Reference: 2201012e-l.docx

1 February, 2022

**SHOALHAVEN STARCHES - PROPOSED MODIFICATION 9 TO MP 06_0228 – NORTH
PACKING PLANT**

DESIGN NOISE VERIFICATION REPORT

Noise Barrier Walls

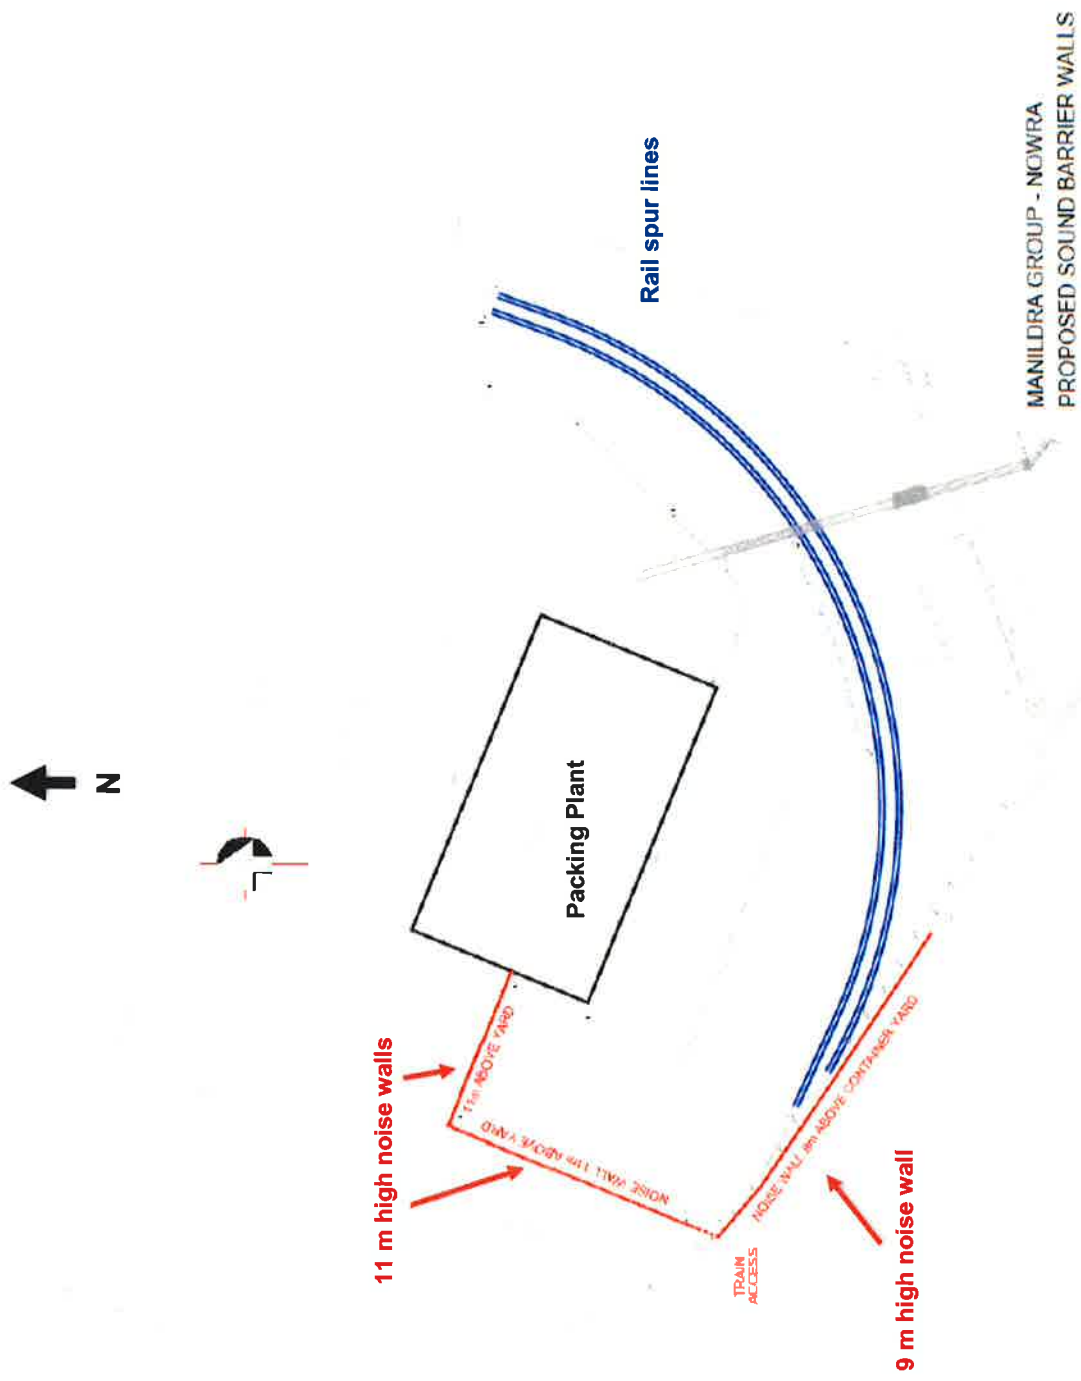
- There will not be any external motors associated with Modification 9.
- e) *permanent sound barriers a minimum 11 m high relative to the finished ground level of the container storage yard. Barriers shall extend along the entire length of the north-western boundary of the container storage area, connecting to the packing plant along the north-eastern boundary (see the figure in Appendix 2I),*

- The current design drawings and proposal adequately reflects the approved sound barrier screening
- f) *permanent sound barriers a minimum 9 m high relative to the finished ground level of the container storage yard, along the south-western side of the rail spur lines, as shown in the figure in Appendix 2I, and*

- The current design drawings and proposal adequately reflects the approved sound barrier screening
- g) *sound barriers shall be constructed as solid masonry walls, or other equivalent material, without holes or gaps, other than a maximum of 50 mm at the base.*

- Both the Day Design 2016 NIA and the Harwood 2016 NIA provided recommendations in relation to the construction of the sound barrier walls. The Harwood 2016 NIA revised the recommended heights of the walls to the 11 metres and 9 metres respectively. However, both assessments recommended a variety of example construction materials that could be suitable, providing that the chosen material achieved a minimum weighted sound reduction index (R_w) rating of 20. There is no requirement acoustically for the sound barrier walls to be of masonry (or acoustically equivalent) construction.

- It is proposed to construct each of the sound barrier walls as follows:-
 - 0.48 mm thick profiled sheet steel (*Trimdeck*) on both sides of a 200 mm (minimum) thick steel frame

- This construction will achieve an R_w 25 – 28 which will be acoustically acceptable.

Location of Building Openings

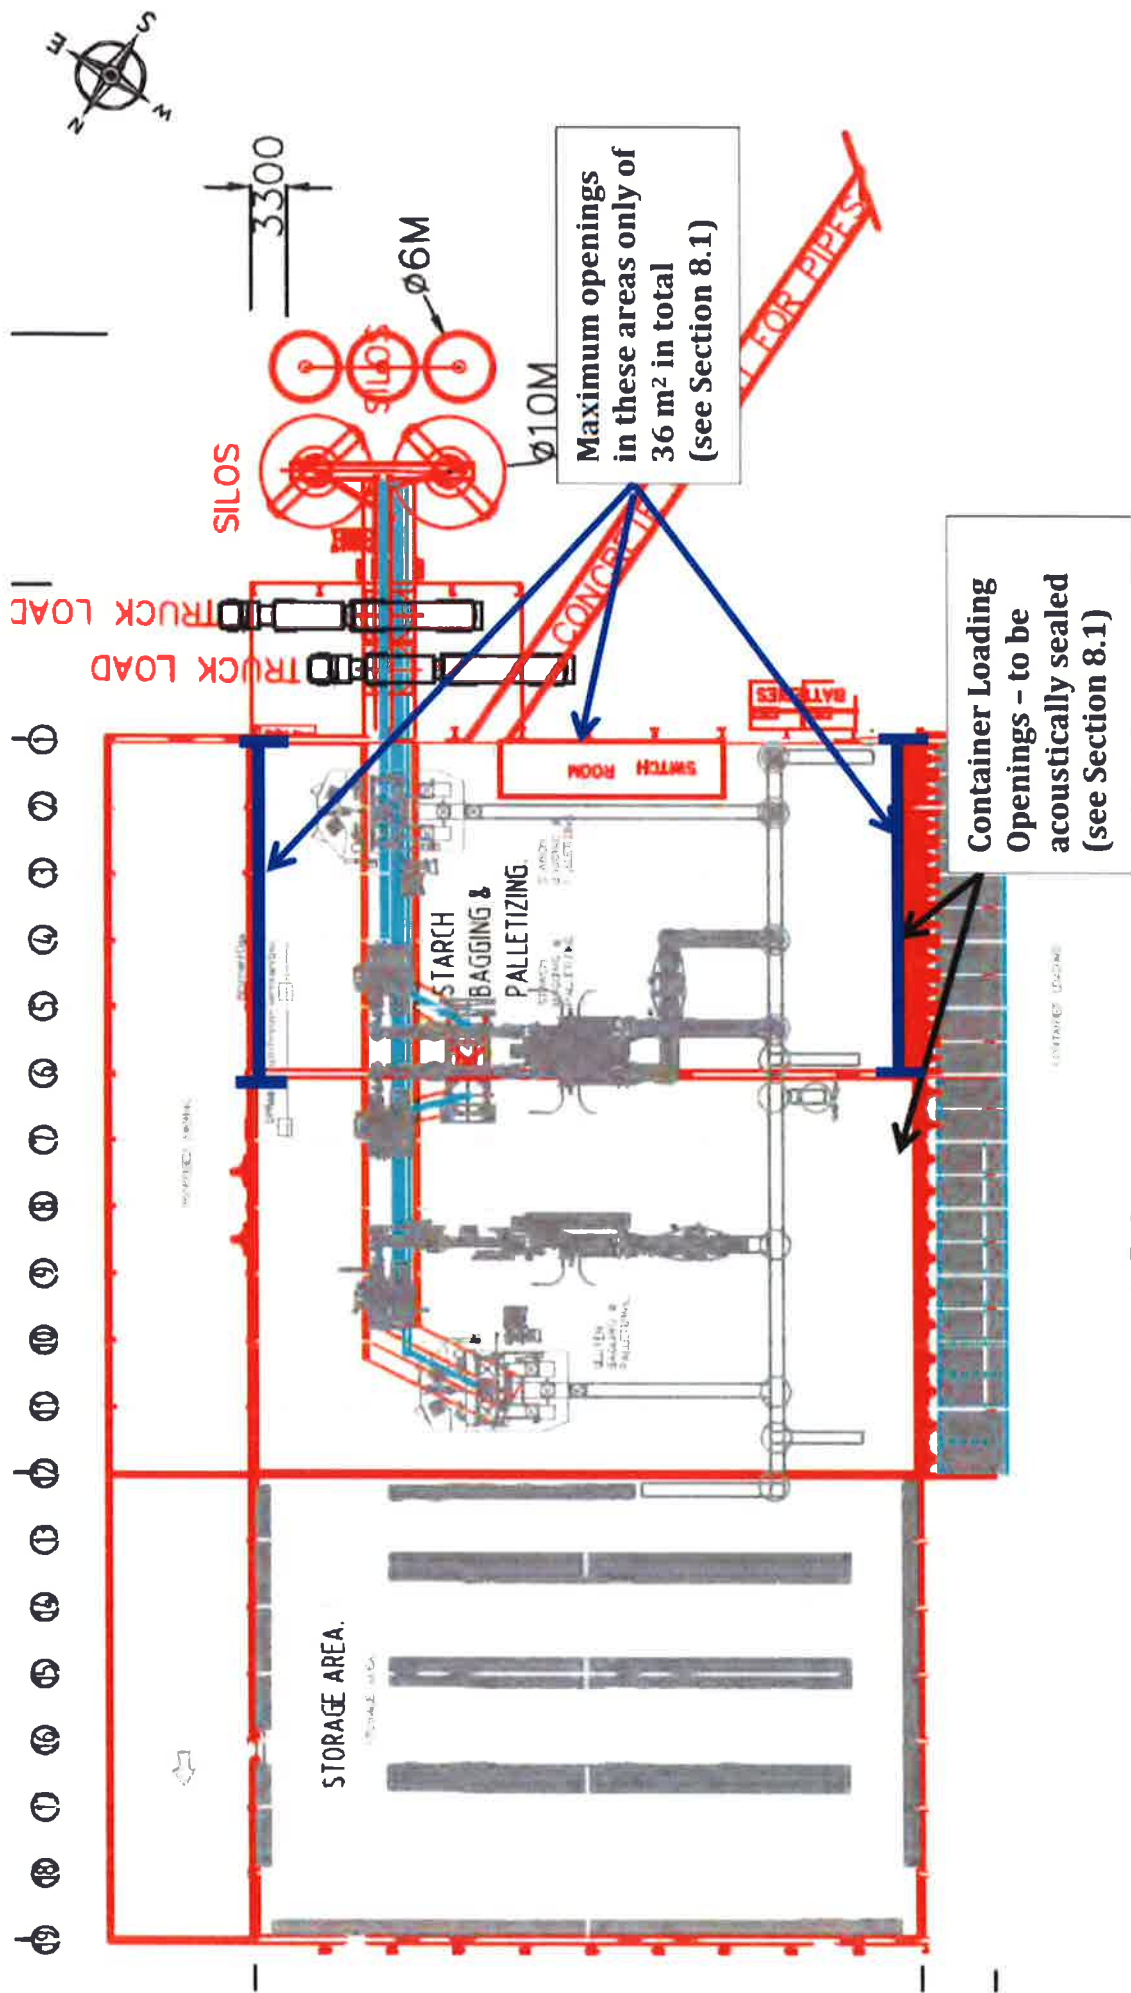
c) building openings without acoustic treatments shall not exceed 36 square metres and shall be located in the south-eastern part of the packing plant building, as shown in Appendix 2I,

- All container pods opening in the southern façade of the building will be acoustically treated as detailed in item a).
- There are two doors, emergency exit PA and a truck entry roller door on both the North East and North west corners of the truckload out area on the northern side of the packing plant building.

- The truck loadout area will be acoustically enclosed with external cladding material that achieves a minimum weighted sound reduction index (R_w) rating of 25 which will be acoustically acceptable.

- The truck entry doors will be interlocked with each other as well as being interlocked with the acoustically treated internal 3 doors to the Packing floor, which is acoustically acceptable.

- There are three roller doors proposed in the northern façade of the packing plant building which will open to the truckload out area. The design of the acoustically enclosed truckload out area will be such that either of the three roller doors in the northern concrete façade of the building will only ever be open when the truck loadout area is closed.

- This design acoustically satisfies the intent of this condition with respect to acoustically treated openings whilst maintaining the acoustical integrity of the building façade.
